Department of Transportation

US-24G (E-X)
El Paso County

RE: Judge Orr Road Commercial Park Preliminary Plan (SP264)

Figure 7 - 2045 Future Year Proposed Lane Geometry

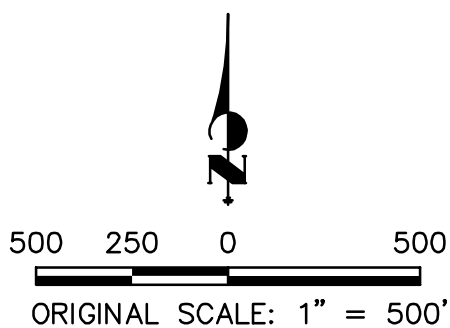
- Future year: Use 2047 (20 years after buildout) as the future analysis year, not 2045.
- Roundabout configuration: Two configurations should be analyzed:

- o Buildout (2027): Use the single-lane roundabout configuration shown in the left image.
 - o Future (2047): Use the multi-lane roundabout configuration shown in the right image, which is anticipated to be needed around 2039 depending on traffic demand.
